ITEM 1.2 (e)

Issue/ Objection:
Solar Access

85 Harrington Street
The Rocks
GOLDEN AGE & HANNAS THE ROCKS

TITLE
RESPONSE TO DoPE
ITEM 1.2 (e)

TITLE
**Diagrams
Solar Access**

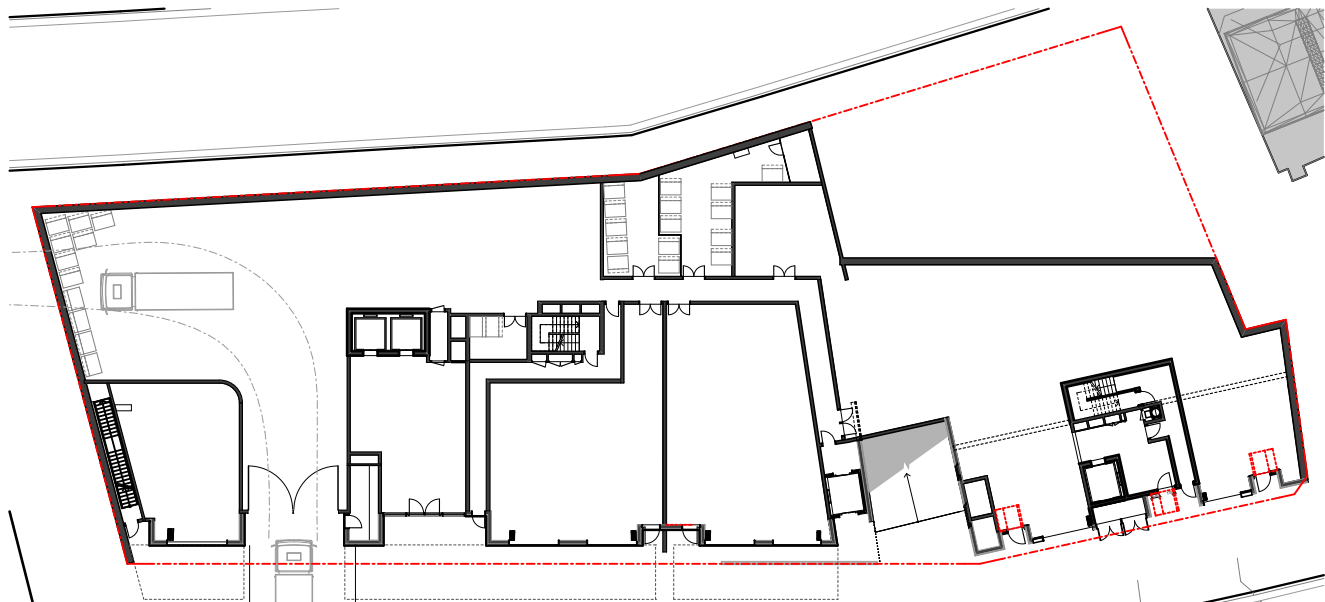
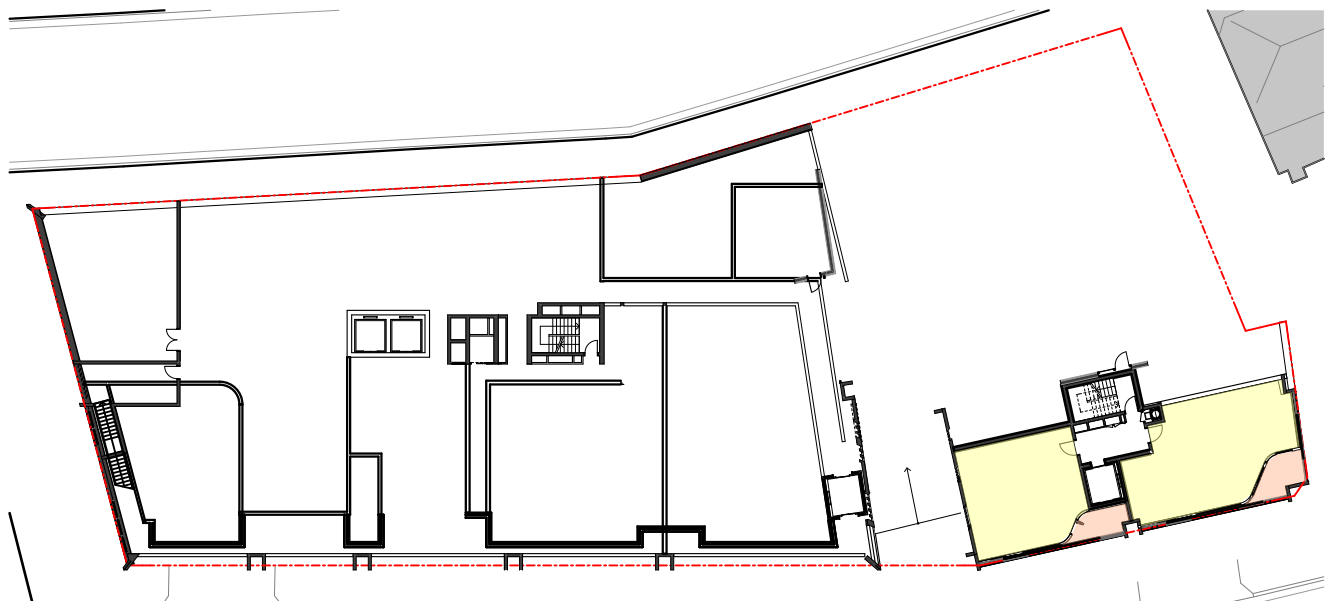
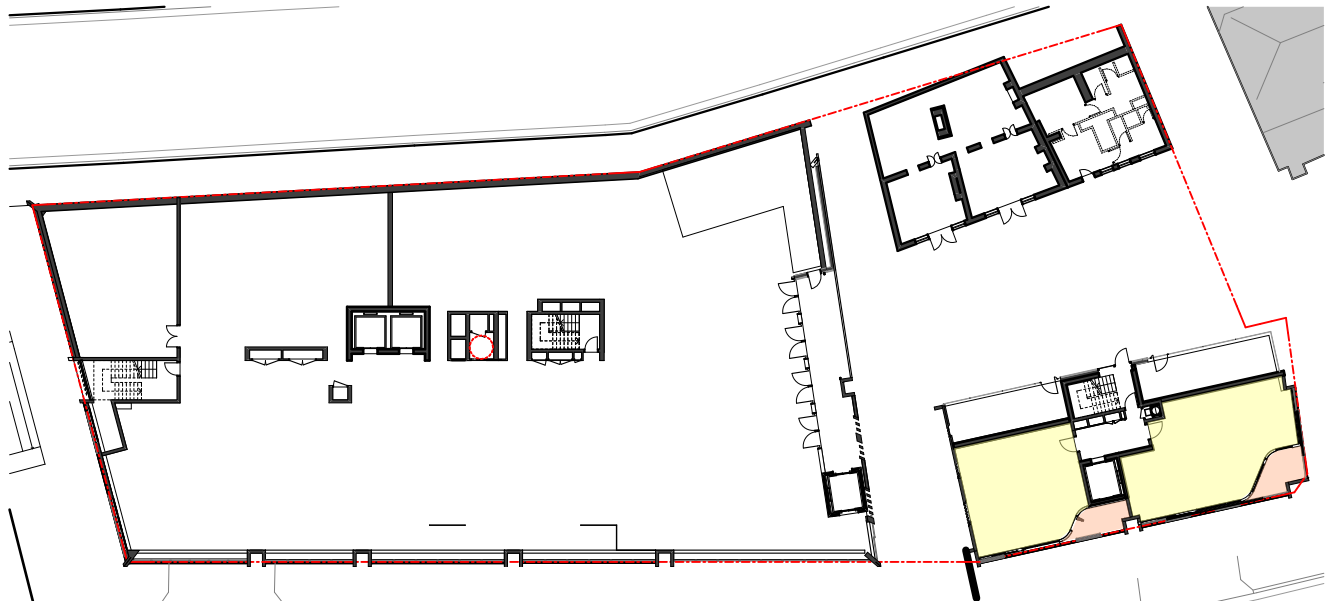
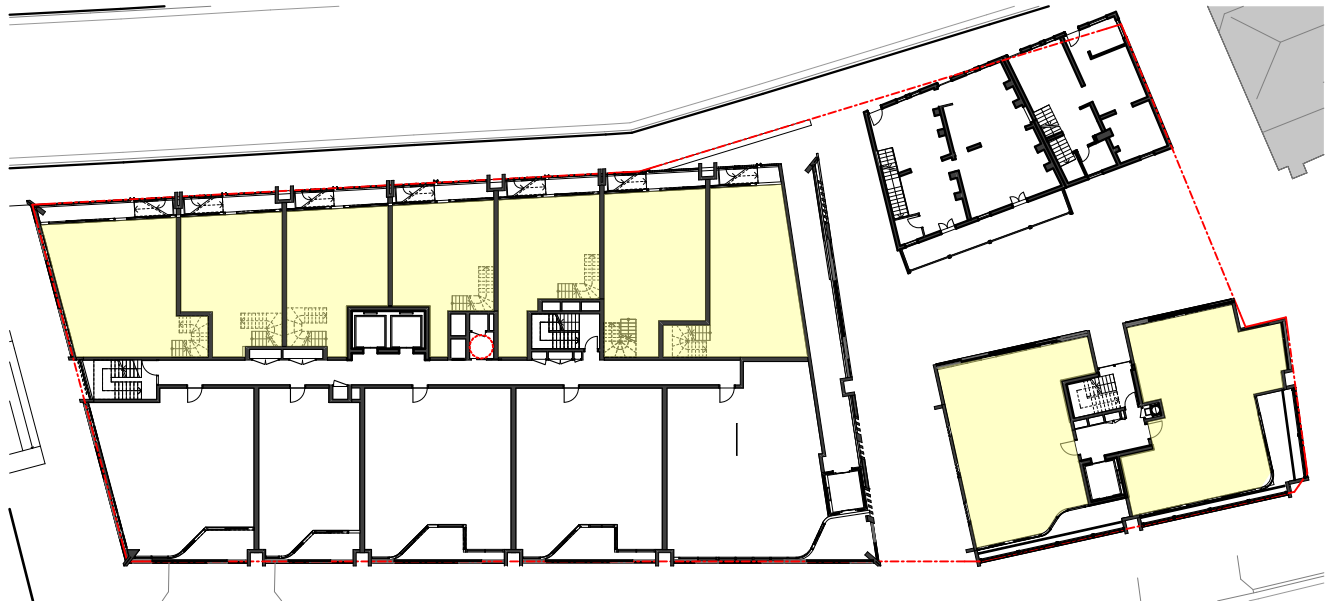
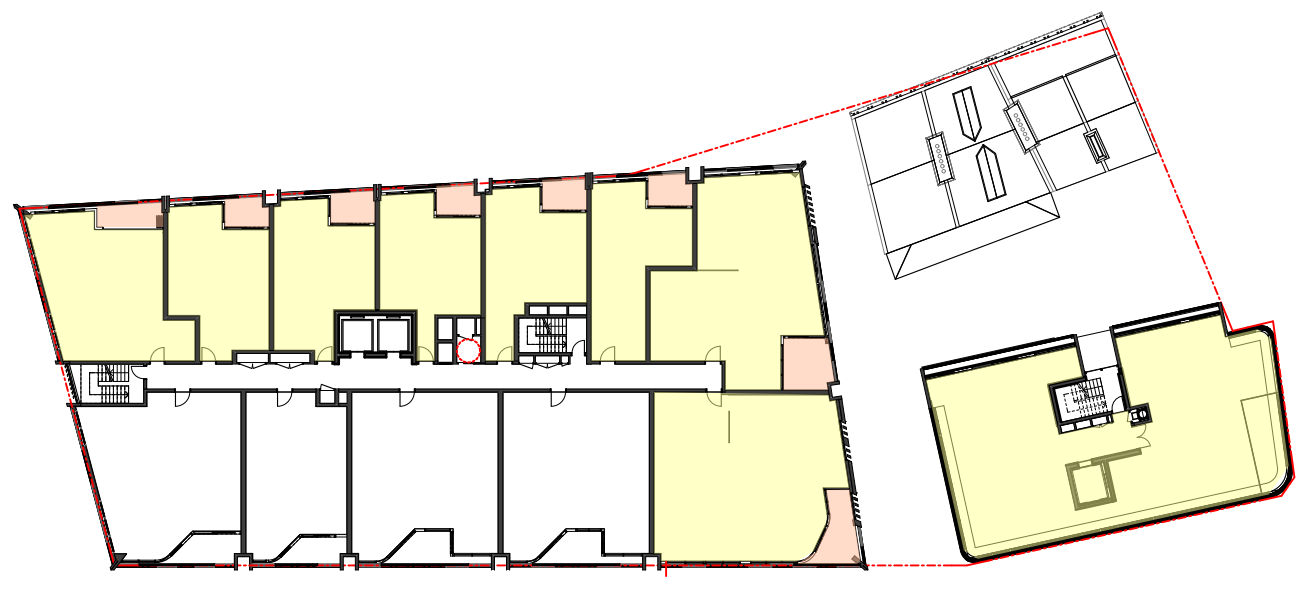
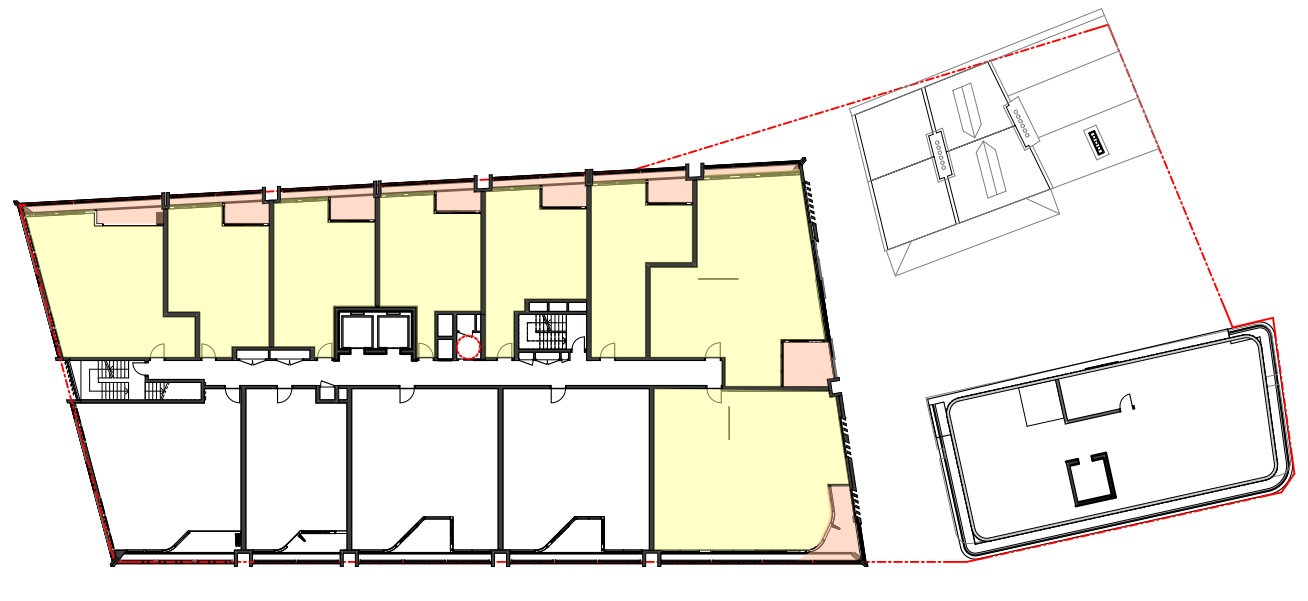
Description:
The proposal indicates 70% of units will receive at least two hours solar access in midwinter (9am to 3pm) and all units will receive at least one hour of solar access in midwinter. Please provide a solar access study demonstrating the above including consideration of the proportion/area of the living rooms and balconies receiving solar access.

Response
The site is located in a dense, urban, city setting. The topography of the site relies upon a design response resulting in a building with a North/South orientation. As such all apartments face an East or West direction and are afforded good solar amenity. The building results in **no single aspect south facing apartments**. An extensive solar access study has been undertaken to show that 70% of units will receive at least 2 hours solar access in midwinter (9am to 3pm)
